Application No 02DRB-00608 (P&F)
Project Name: ALBUQUERQUE SOUTH UNIT 3
Agent: Aldrich Land Surveying, Inc.

DEVELOPMENT REVIEW BOARD
May 15, 2002
Project #1001896

Project # 1001896
02DRB-00607 Major-Bulk Land Variance
02DRB-00608 Minor-Prelim&Final Plat Approval

ALDRICH LAND SURVEYING, INC. agent(s) for CURB, INC. request(s) the above action(s) for all or a portion of Tract(s) E & 8, **ALBUQUERQUE SOUTH UNIT 3**, zoned C-2 (SC), R-2, C-2/O-1, SU-3 R-3, located on SNOW VISTA BLVD. SW, between DE ANZA DR. SW and BLAKE ROAD SW containing approximately 104 acre(s). [REF: S-1082-MP-1, DRB-94-168/S-94-61] (M-9)

Drawn By:	RJA	Date:	04-03-02
Checked By:	TA	Drawing Name:	01068BP2.DWG
Job No.:	01-068	Sheet:	2 of 3

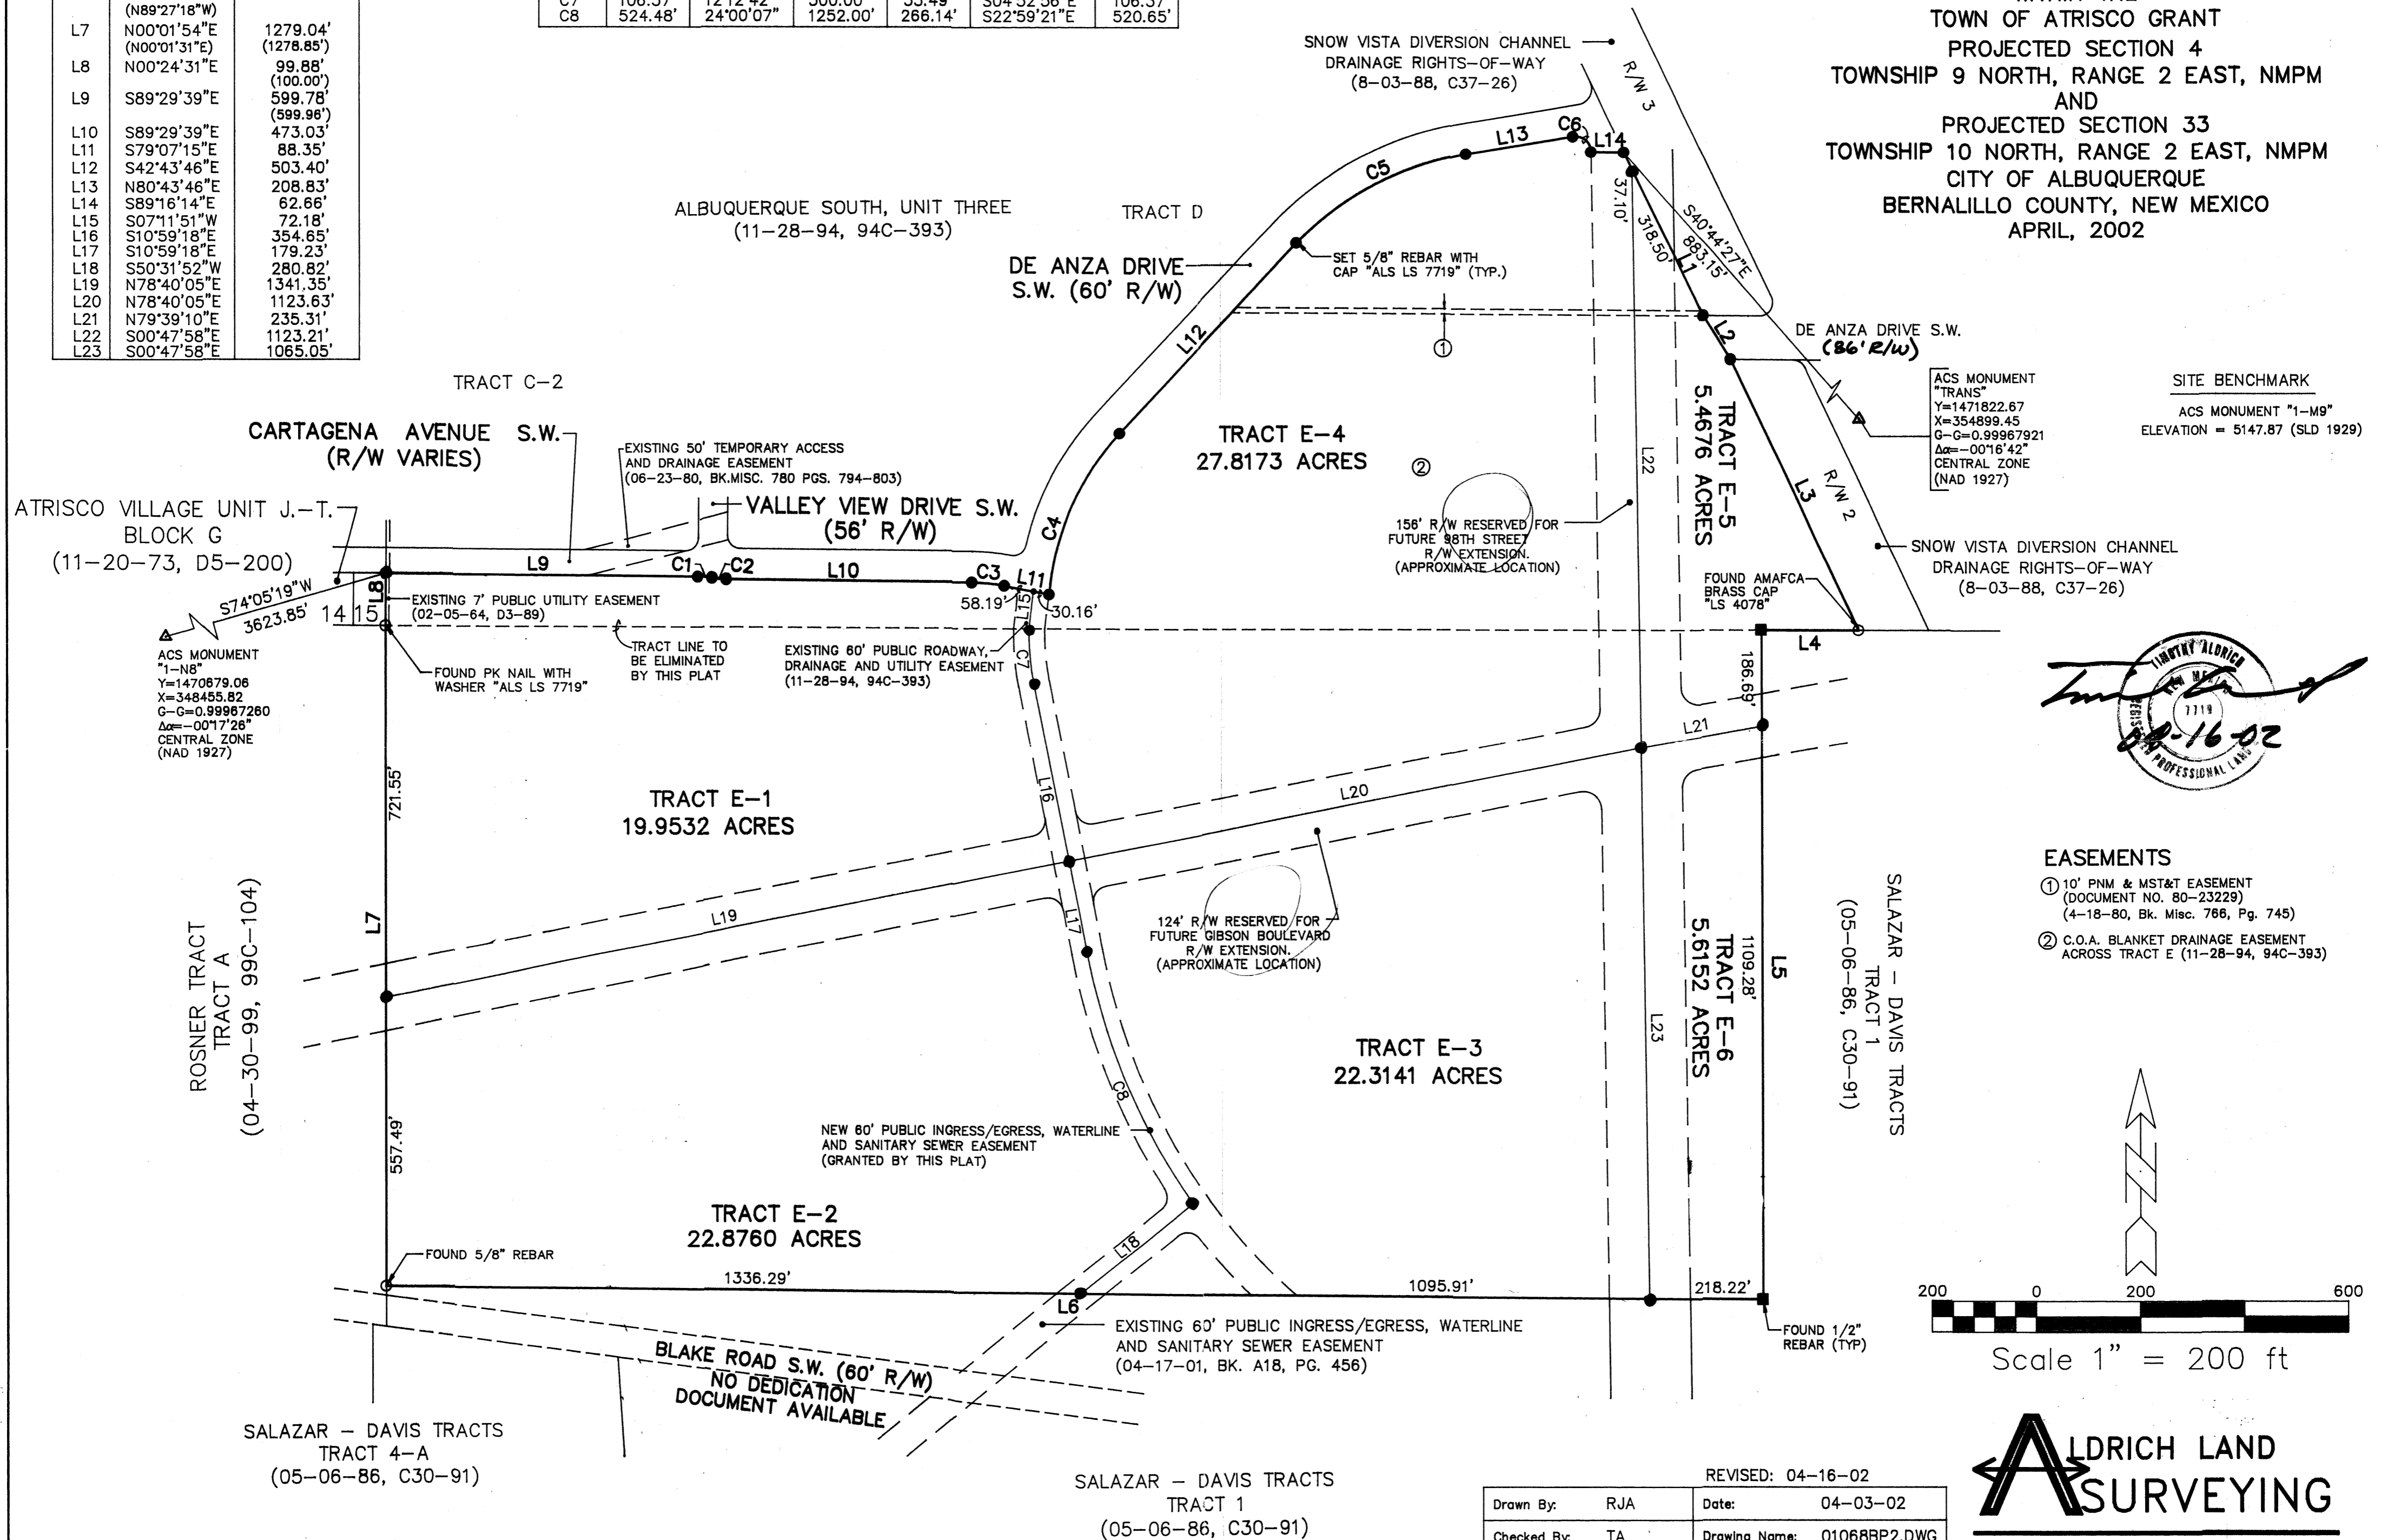
AMAFCA 1. No objection to requested action. 2. Reference "AMAFCA" in call-out for Snow Vista Channel. 3. AMAFCA will sign the plat.

PNM currently reviewing the Bulk land Plat for Albuquerque South, Unit 3. PNM will be requesting a ten (10) foot easement along the tract line to be eliminated by this Plat for an existing overhead electric powerline.

Public roadway easements need to be granted at this time and the location should be determined as best as possible for this stage of development. No objection to the bulk land variance.

Drawn By: RJA	Date: 04-03-02
Checked By: TA	Drawing Name: 01068BP2.DWG
Job No.: 01-068	Sheet: 2 of 3

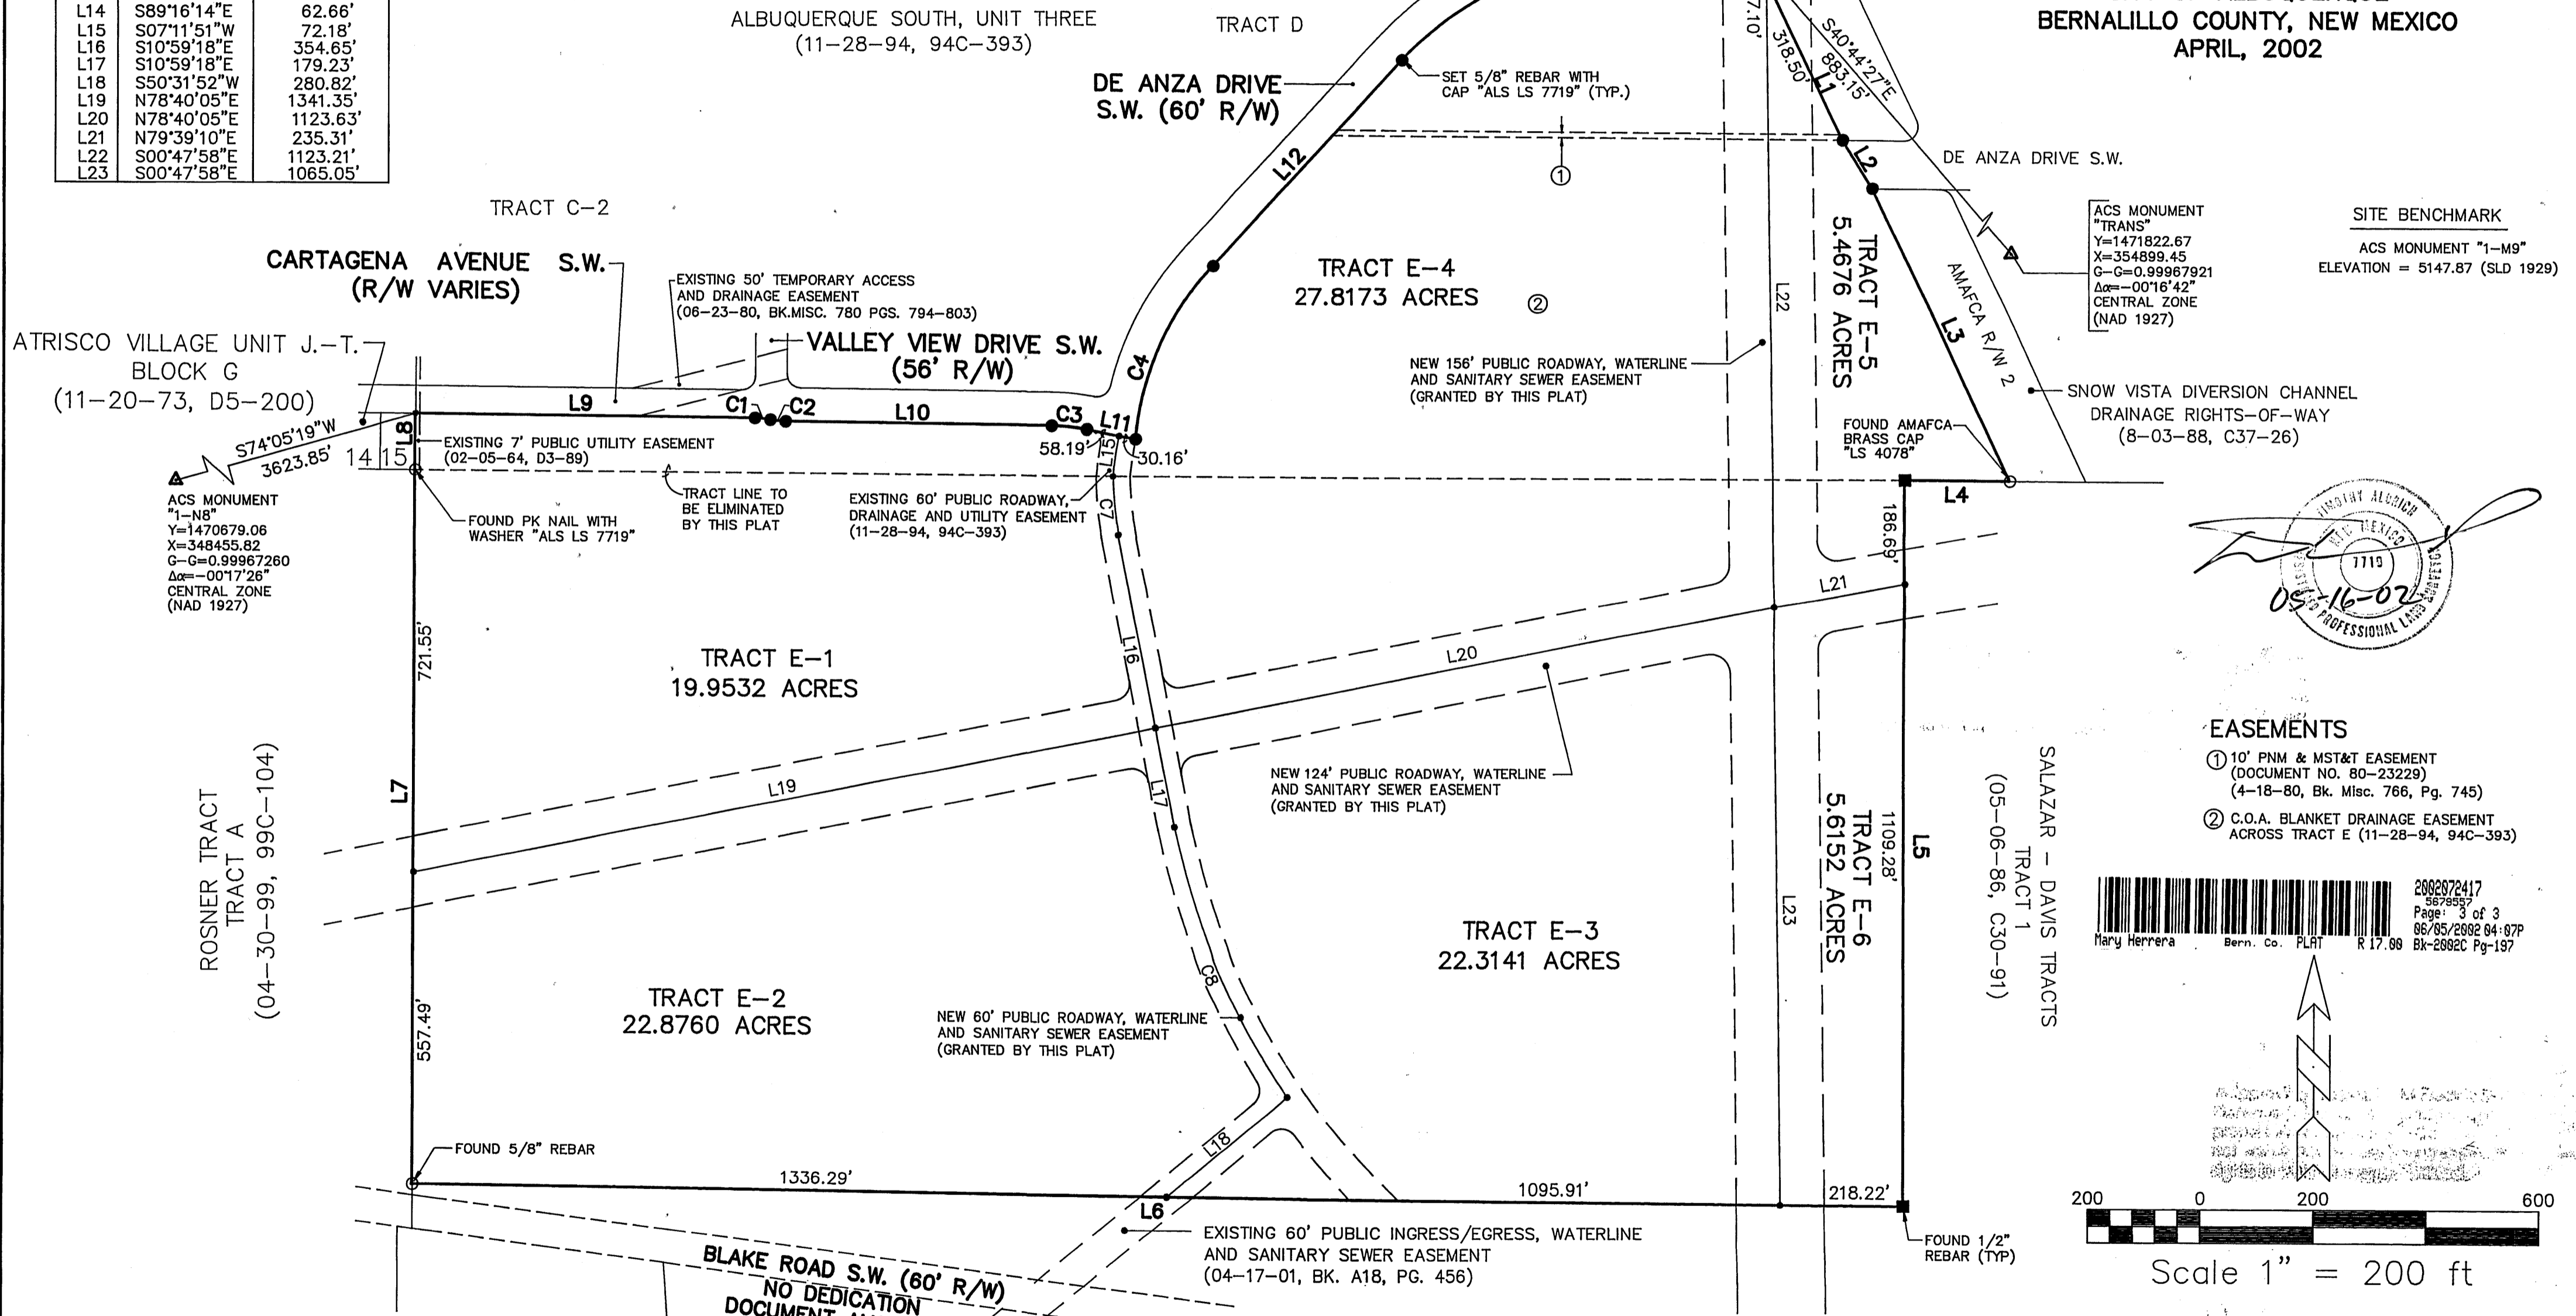
- TRANSPORTATION: include the crossing structure for SNOW Vista Channel in the
- UTILITIES: _____ BULK LAND VARIANCE
- CITY ENGINEER / AMAFCA: _____ Note.
- PARKS / CIP: _____
- PLANNING (Last to sign): See comments
 - Planning must record this plat. Please submit the following items:
 - The original plat and a mylar copy for the County Clerk.
 - Tax certificate from the County Treasurer.
 - Recording fee (checks payable to the County Clerk). RECORDED DATE: _____
 - Tax printout from the County Assessor.
 - Include 3 copies of the approved site plan along with the originals.
 - County Treasurer's signature must be obtained prior to the recording of the plat with the County Clerk.
 - Property Management's signature must be obtained prior to Planning Department's signature.
